**Re: PA22-015 - Colvin PRD – Technical Review 1  
CORE Project No. 21387**

The purpose of this letter is to provide a response to the review comments for PA22-015 - Colvin PRD – Technical Review 1 dated December 14, 2022. We have addressed each comment and revised the plan/documentation accordingly. This letter contains the review comments immediately followed by our response to each in bold lettering.

SHEET	OF
C4.01	7
PROJECT NUMBER	
21387

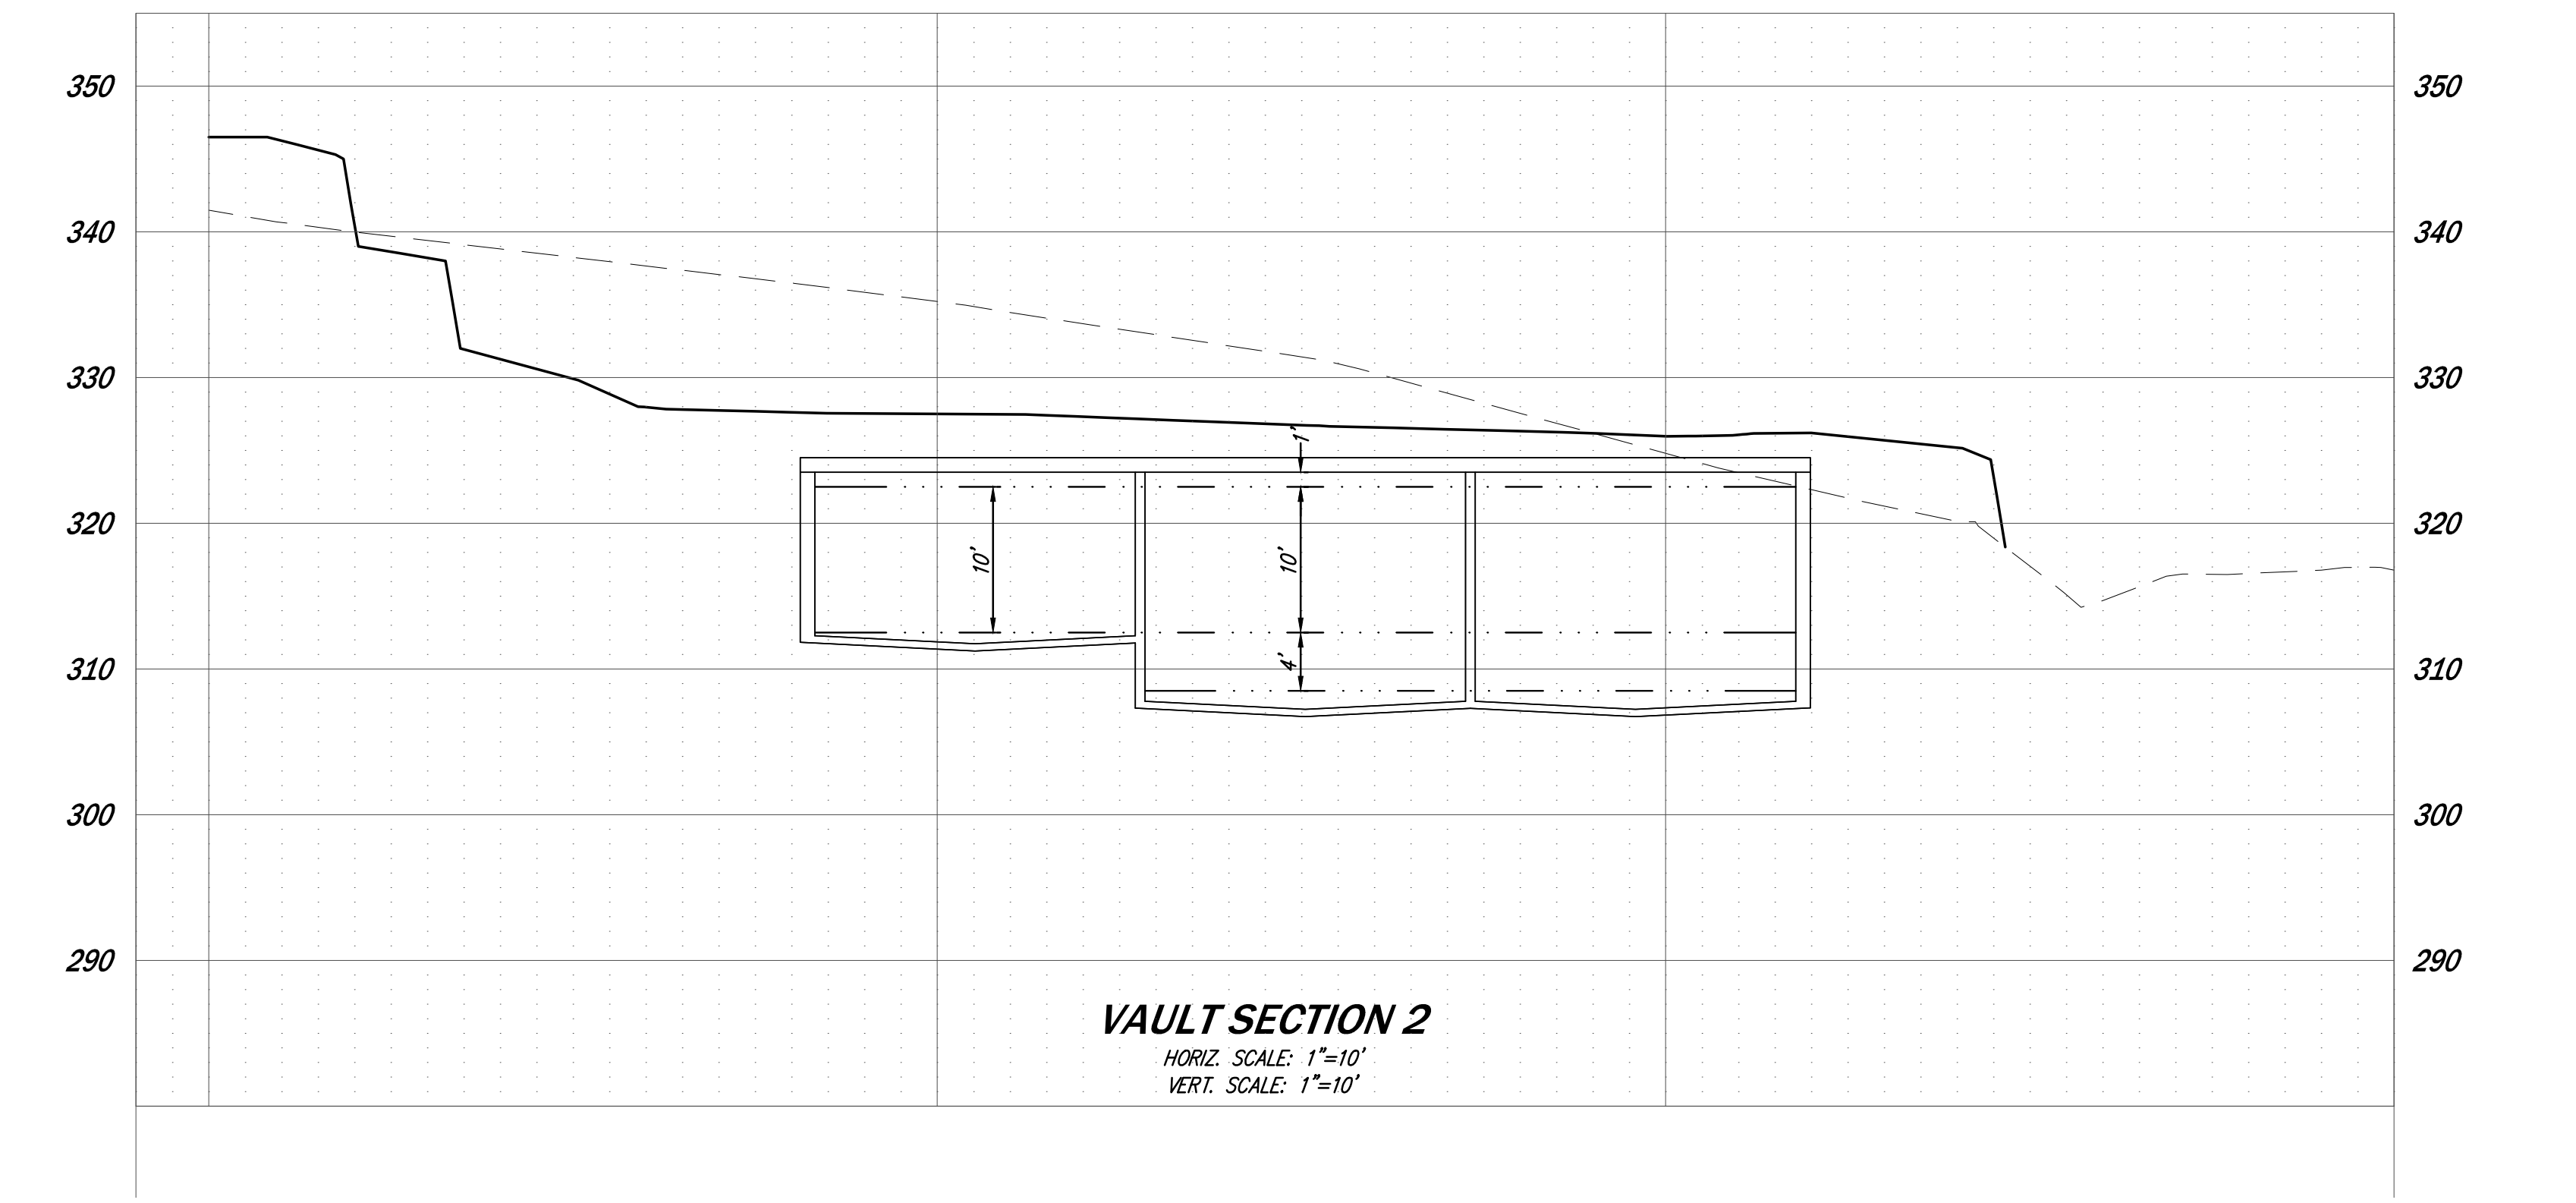
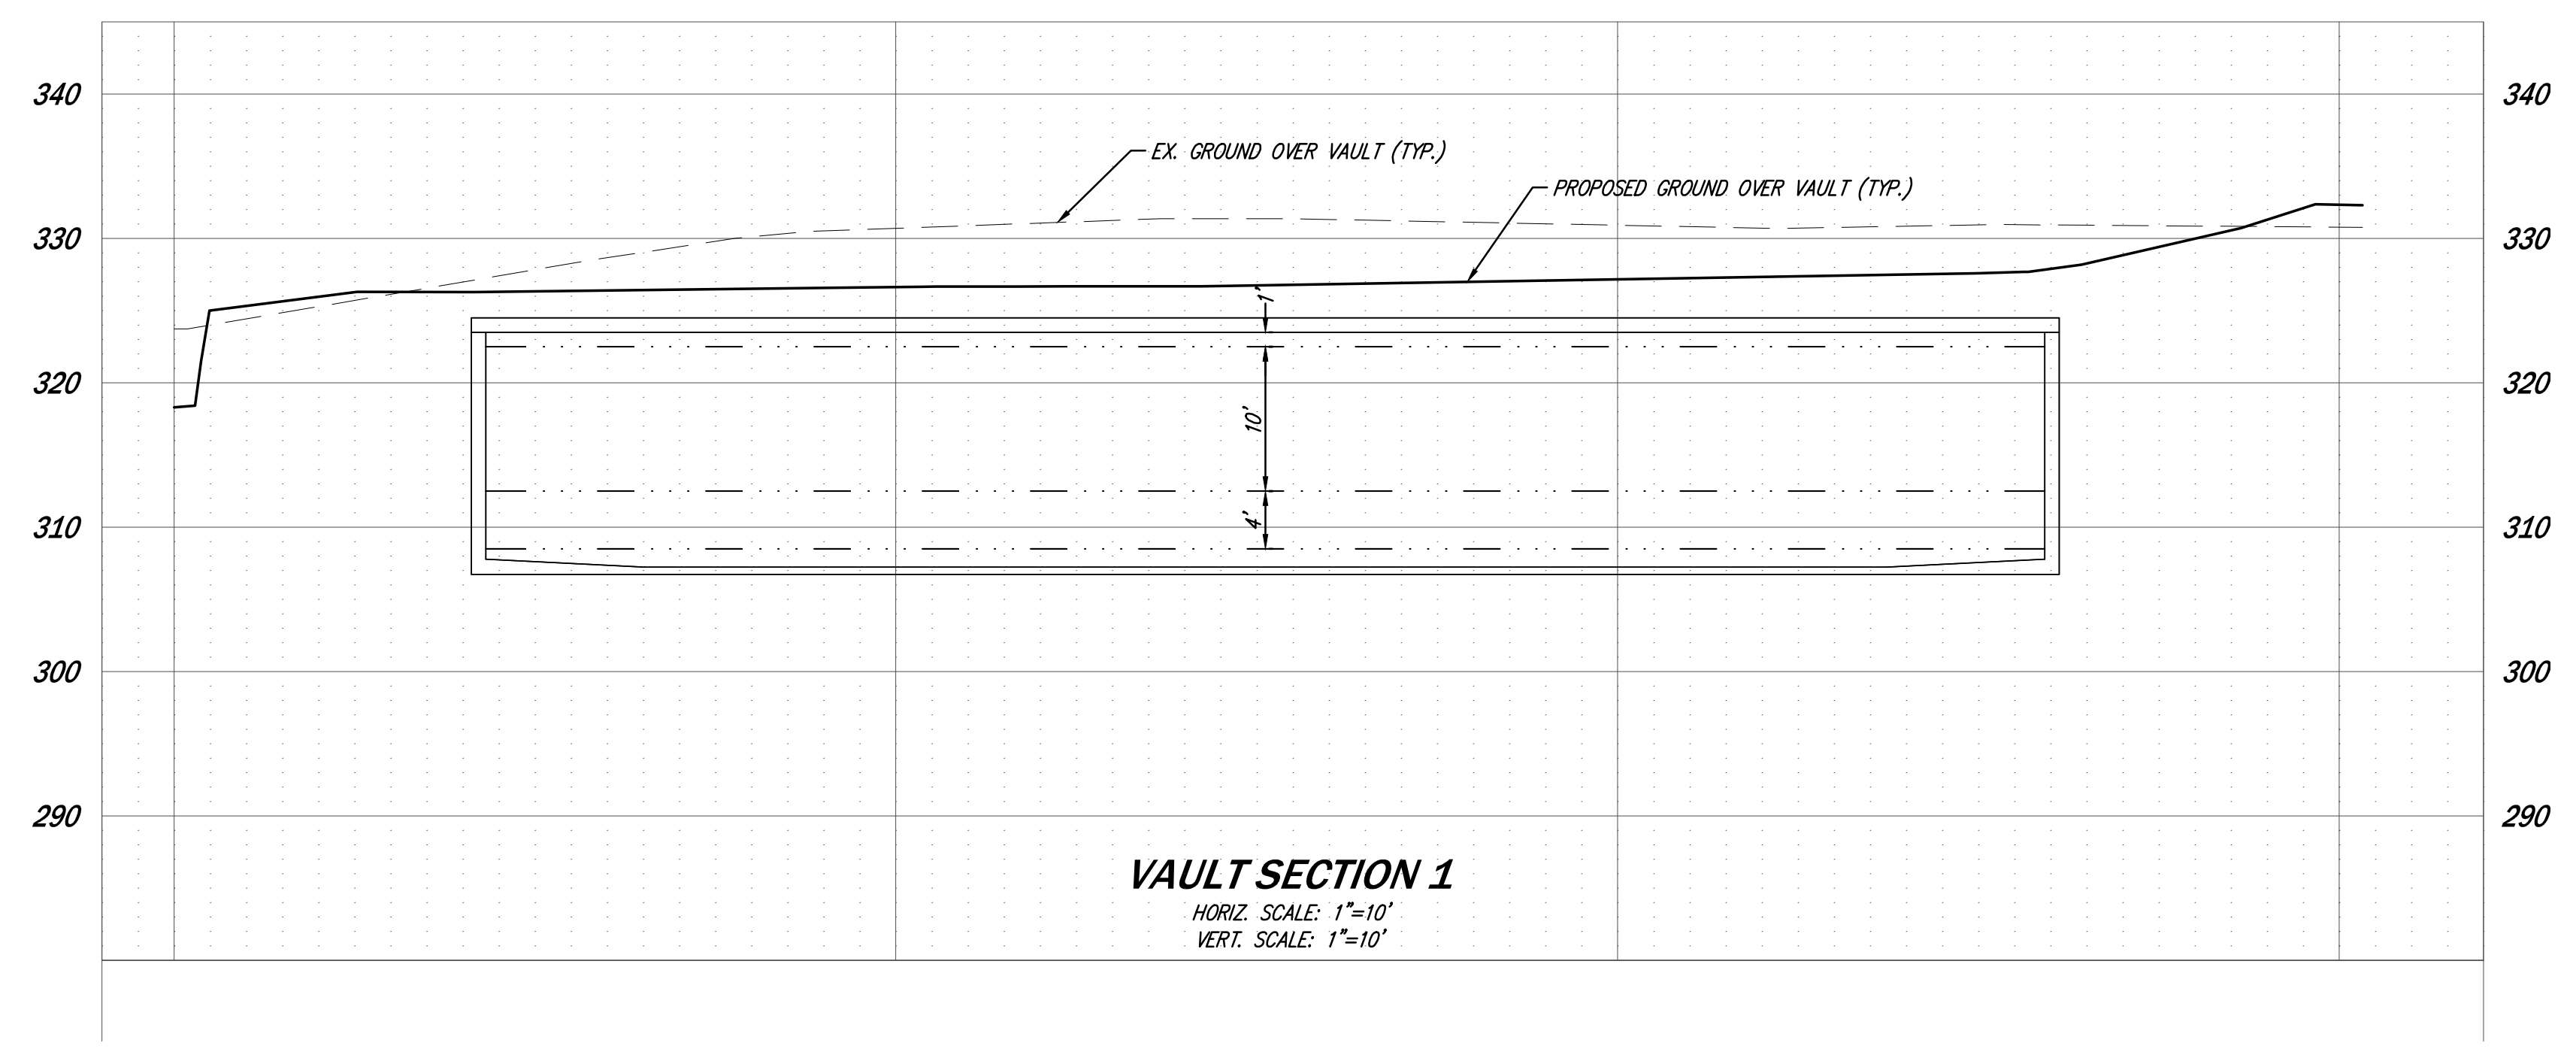
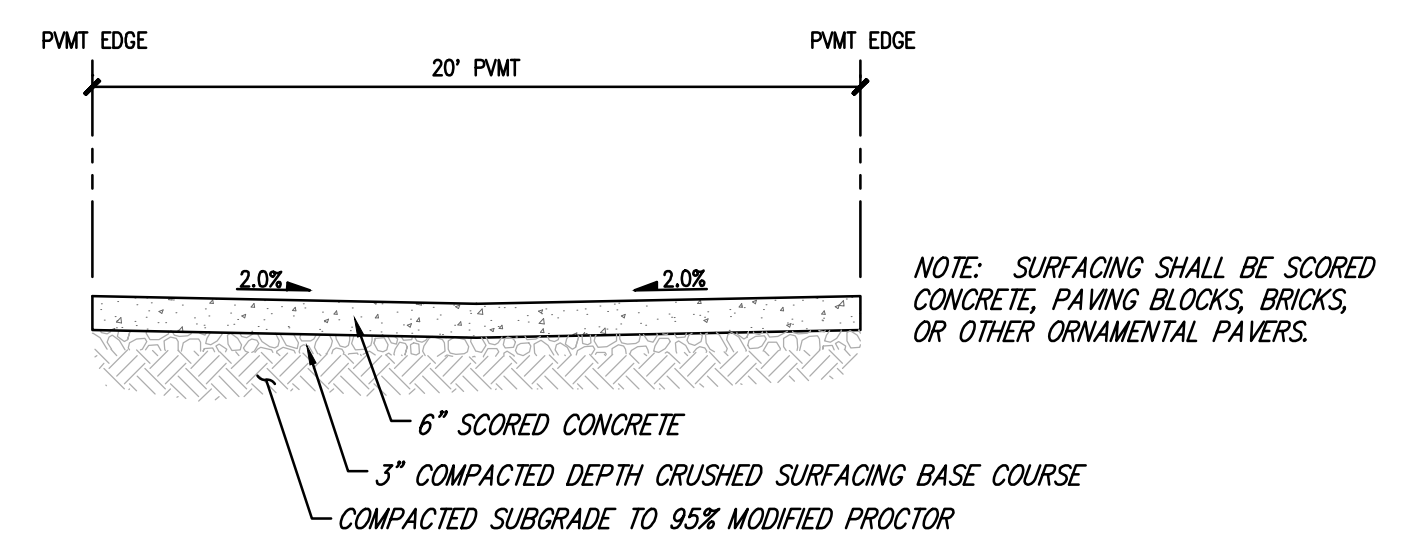
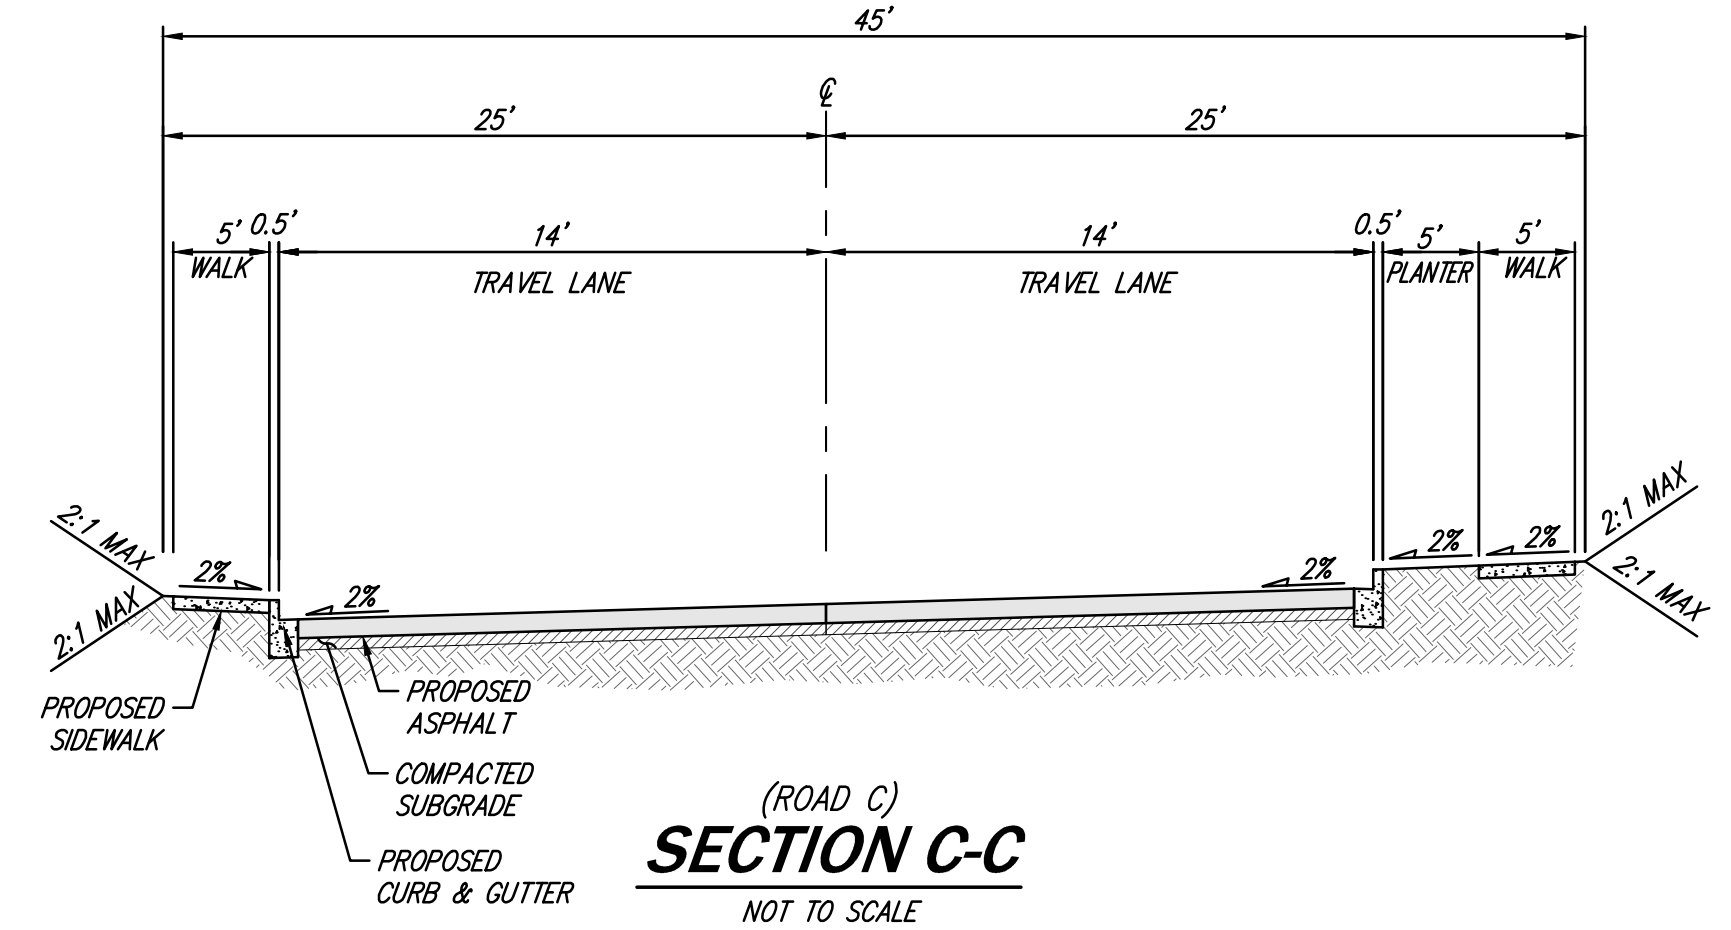
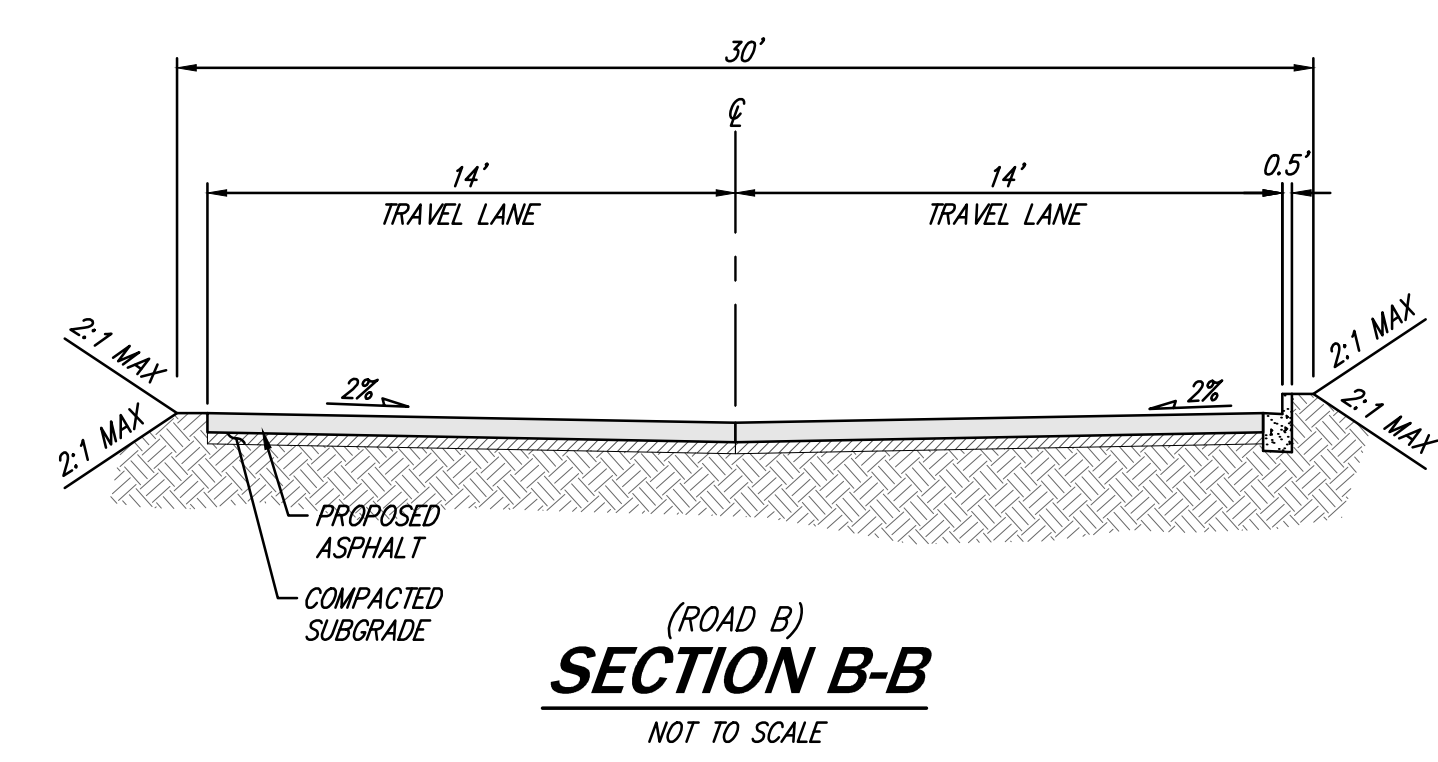
21. 15' Easement will be needed for storm run between CB4-CB5.

22. Should be considered bypass in the drainage model.

23. 5' private drainage easement needed for these wall drains.

24. Should be considered bypass in the drainage model.

25. These must be thru-curb inlets.

26. How is the upstream flow being collected and routed through the site.

***Response: An easement has been added as requested.***

***Response: This area has now been considered as bypass. Please review report and plans.***

***Response: Easement has been added per request.***

***Response: This area has now been considered as bypass. Please review report and plans.***

***Response: Revised as requested.***

***Response: Information regarding this has now been added to this sheet and sheet C4.25.***
